Application Reference: 2025/0796

Site Address: 7 Wood Cottages, Sheffield Road, Spring Vale, Sheffield, S36 8ZR

Introduction: This application seeks full planning permission for the erection of side first floor extension over the existing and previous ground floor extension.

drg title
Proposed Elevations

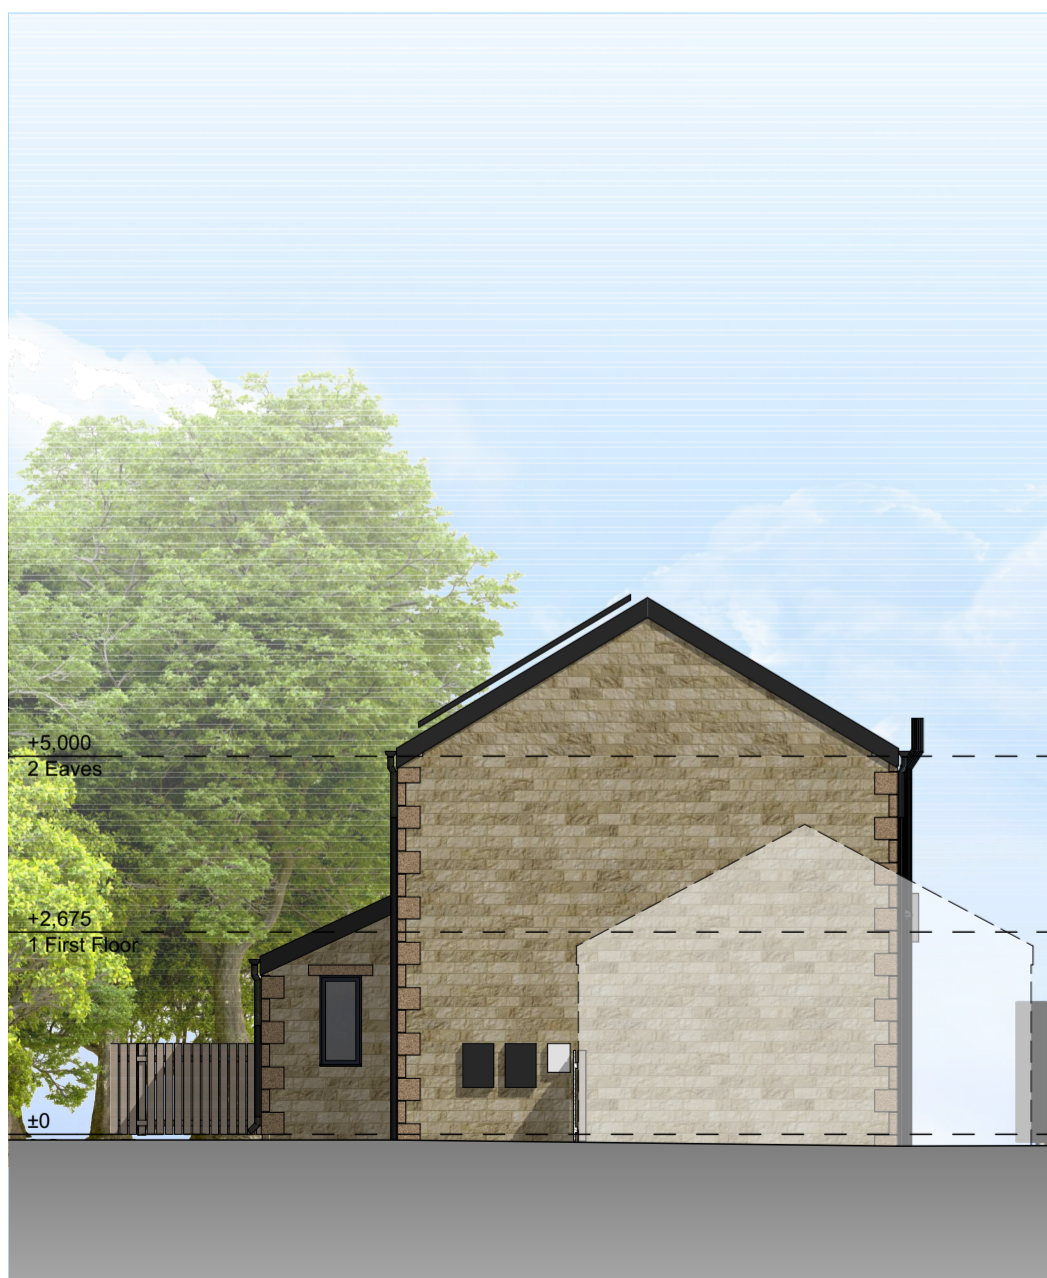
With an existing set back of the ground floor extension on both the front and rear elevations, a further first floor set back has not been included. A step down of the roof has been included, which along with the existing front and rear set backs demonstrate subordination to the host dwelling, as required by the SPD house Extensions and Other Domestic Extensions

Following a request for amended plans, the extended dwelling would feature anthracite coloured, window frames of a similar appearance throughout. Matching cills and lintels are also to be included in new windows within the extension and retrofitted to existing windows. The existing glazed doors with the extension would also feature a new matching lintel, and the largest proposed first floor window within the principal southwestern elevation of the extension would feature mullion to match the existing windows within the original house.

The above amendments to the proposal help preserve much the character of the original dwelling whilst allowing the preference of the applicants be achieved, through the change from cream to anthracite coloured window frames, achieved through replacement or refinishing of existing windows. It is unfortunate that fenestration within the extension remains asymmetrical in comparison to the original dwelling, but much of the ground floor of the extension remains hidden from view by an established hedgerow. The proposed first-floor aspect of the extension is much more visible, but its impact is reduced with the inclusion of at least one of the two front elevation windows reflecting an almost identical design to the windows featured within the original dwelling.

On balance, with clear subordination shown in relation to the host dwelling, along with the positive design aspects featured within the amended plans, and limited impact within the street scene, these would outweigh the impact caused by the asymmetrical fenestration within the extension and colour choice of windows across the extended dwelling.

The amended plans propose the creation of an additional storey above the existing ground floor extension, located on the northwestern elevation of the original dwelling. Windows frames throughout the original dwelling would be replaced or refinished with anthracite coloured window frames to match the existing and proposed windows within the extension. In contrast, new cills and lintels would be added to both existing and proposed windows within the extension to match the existing window openings of the original dwelling. The largest proposed

first floor window of the extension would also feature a mullion to match the windows of the original dwelling.

drg title
Proposed Floor Plans

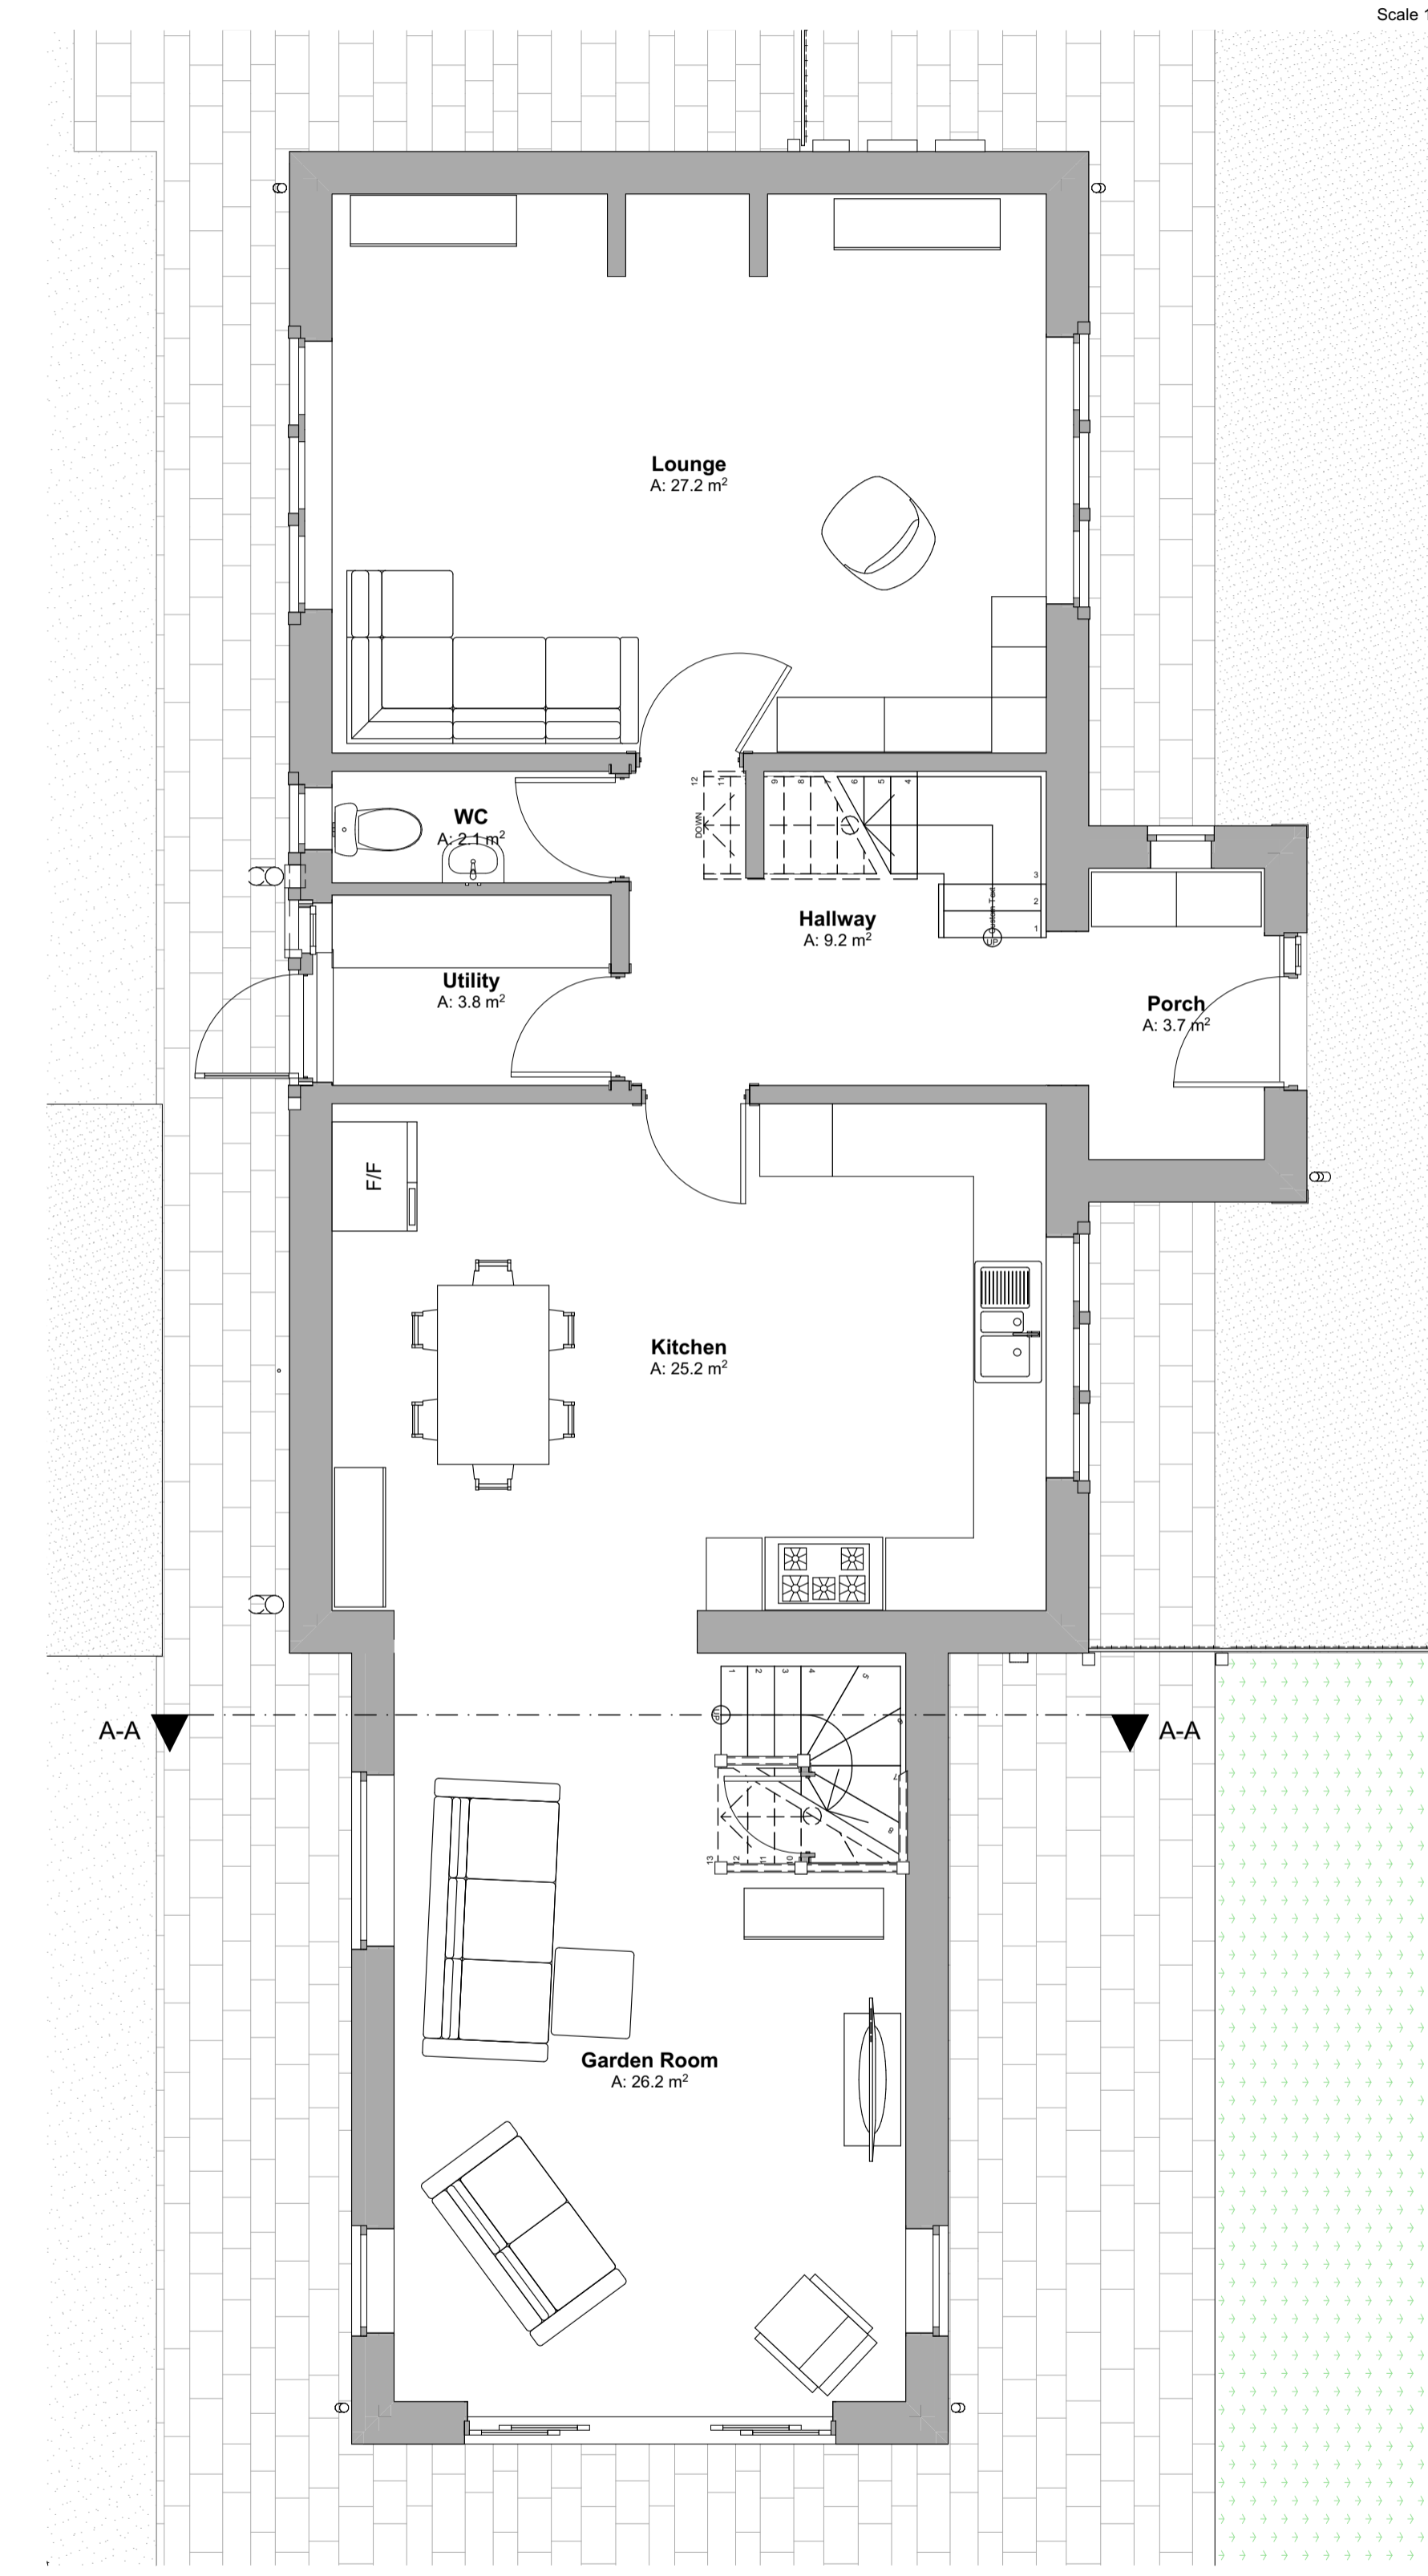
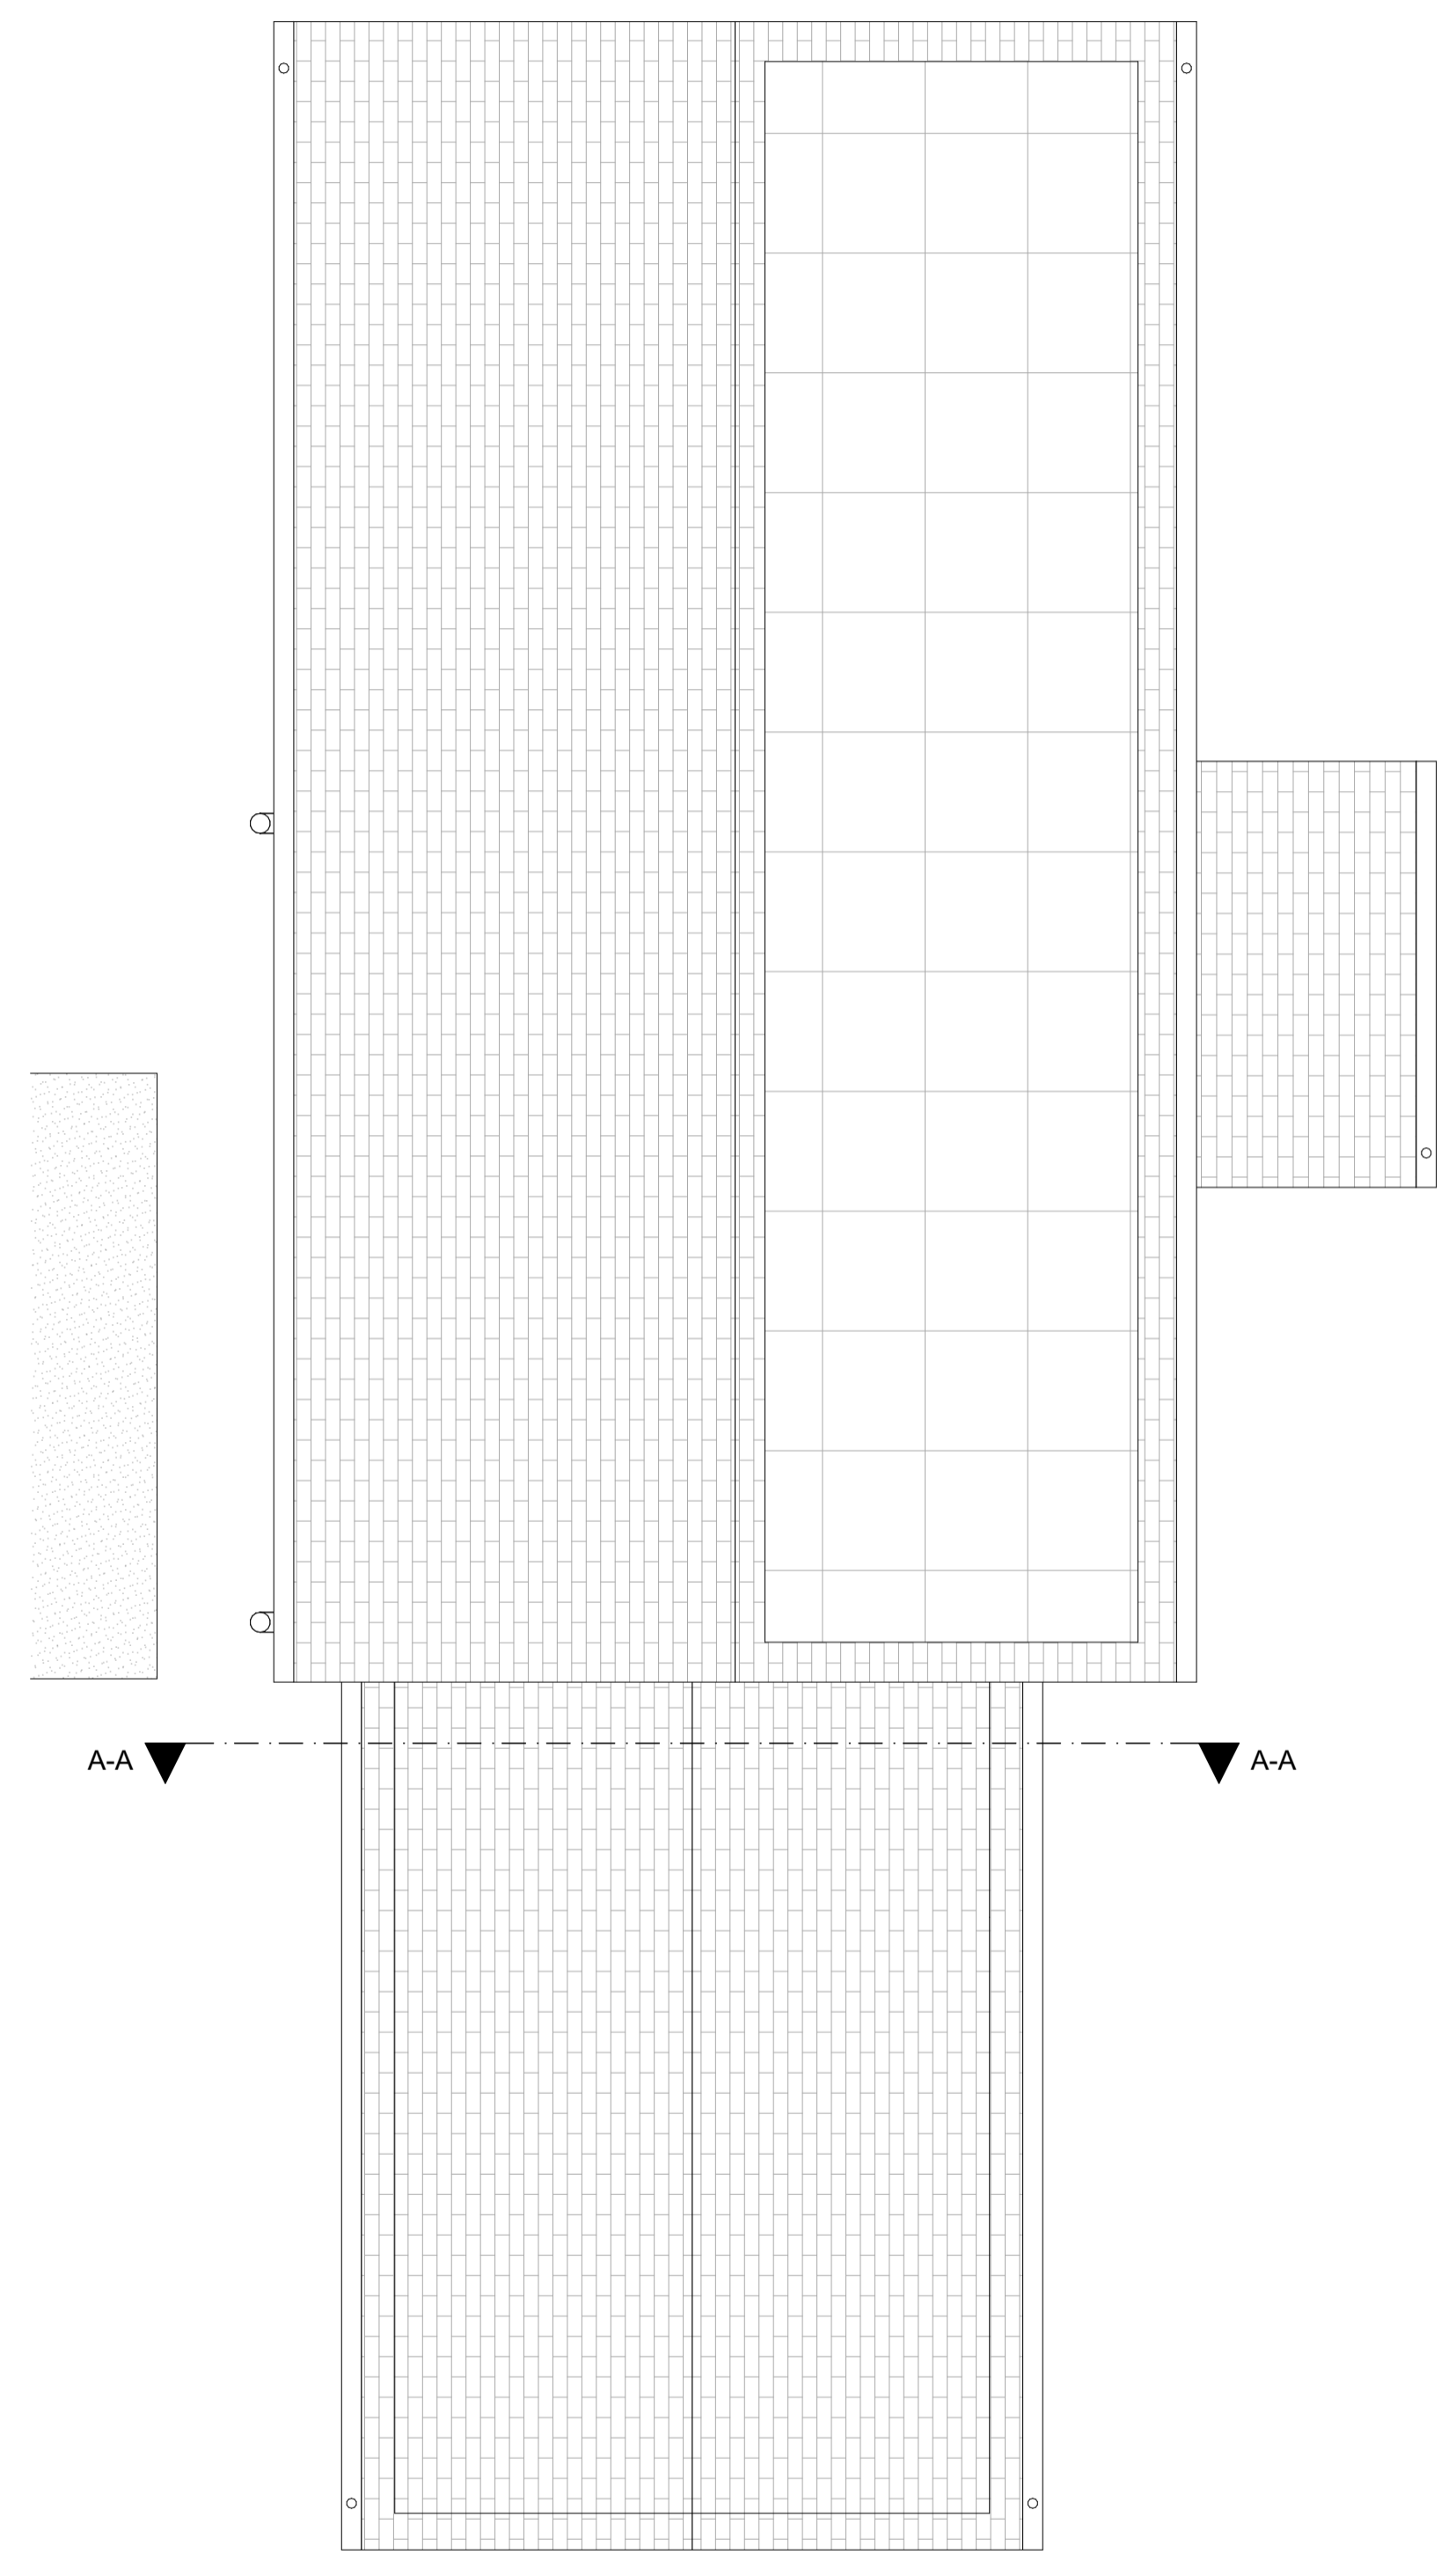
As the proposal is for a first-floor extension above an existing ground floor extension, the footprint of the dwelling would not be increased but there would be an increase in internal floorspace of approximately 26sqm (32sqm gross), this would mirror the existing ground floor extension.
